State of Washington
DEPARTMENT OF FISH AND WILDLIFE

SUBJECT: WDFW COMMENTS ON SV-25-00001 Allen Shoreline Variance

320 MORNING DOVE LANE
A PORTION OF THE SE 1/4 OF THE SE 1/4 OF SECTION 22, T. 20 N., R. 14 E., W.M.
KITITITAS COUNTY, STATE OF WASHINGTON

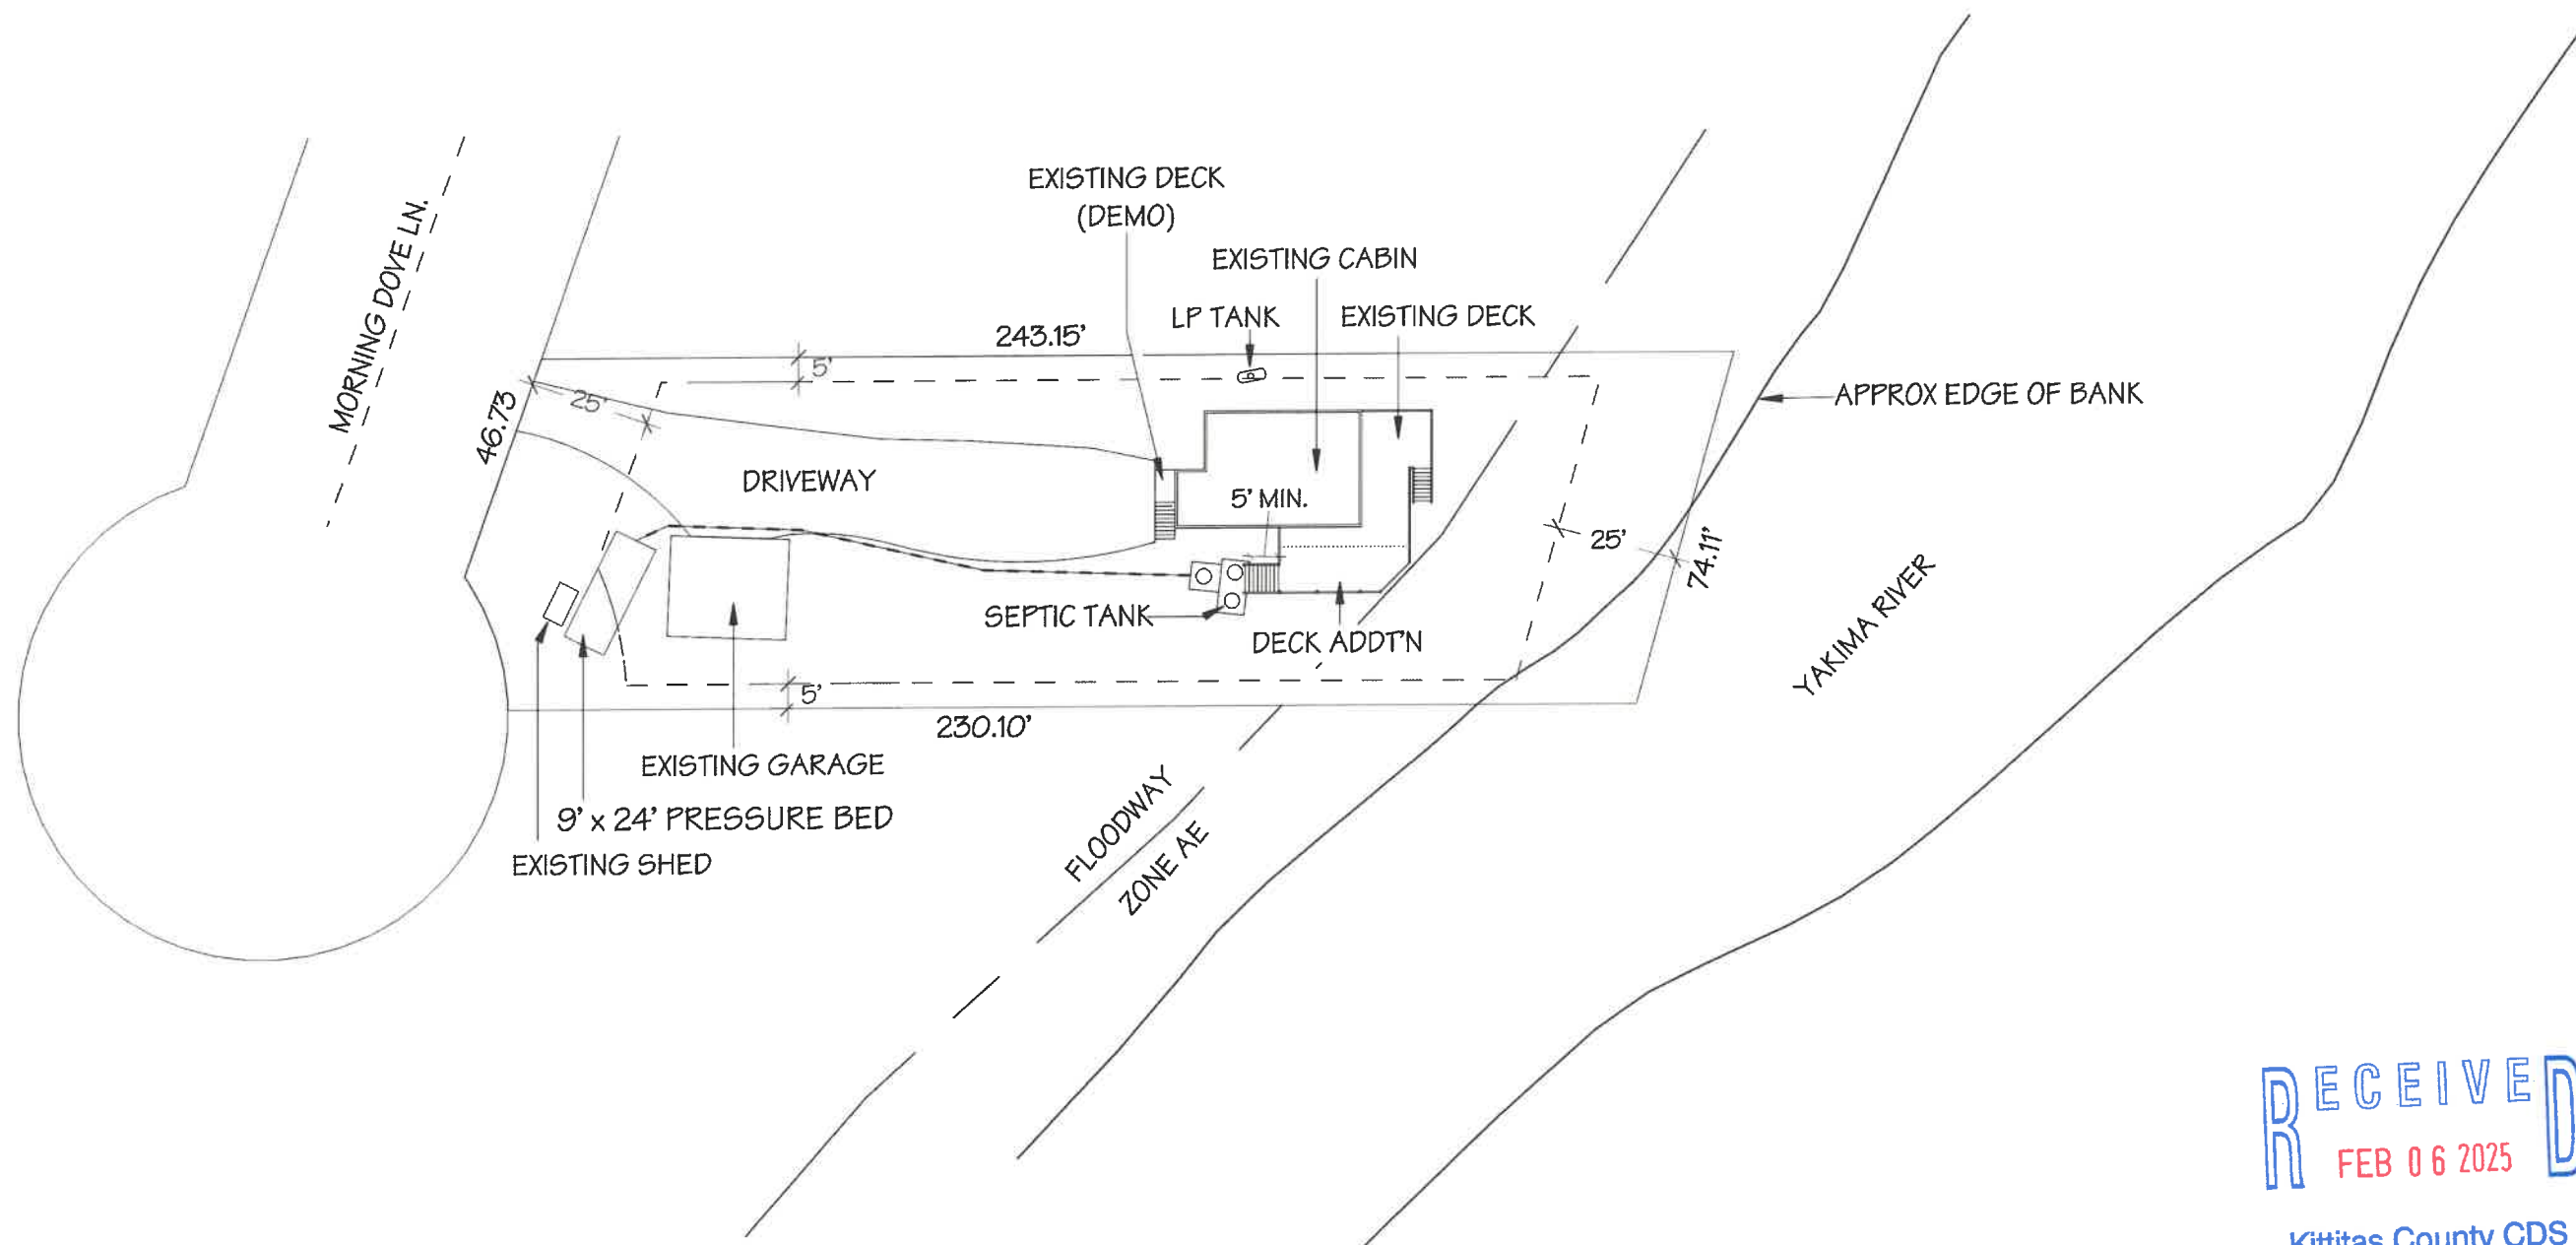
The proposed project will expand the deck by 179 square feet into the Shoreline buffer along the Yakima River and proposes planting 20 livestakes along the bank as mitigation. The proposed mitigation is insufficient as proposed and WDFW recommends a more robust planting plan for the shoreline that includes monitoring, maintenance, reporting, and permanent protections to ensure the additional encroachment into the buffer does not negatively impact aquatic resources. WDFW recommends 1) that the mitigation planting area be at least as big as the area of encroachment (179 square feet), 2) that the newly vegetated area have at least 80% survival after three years, and 3) that there are permanent protections on the mitigation area associated with the proposed permanent encroachment into the buffer.
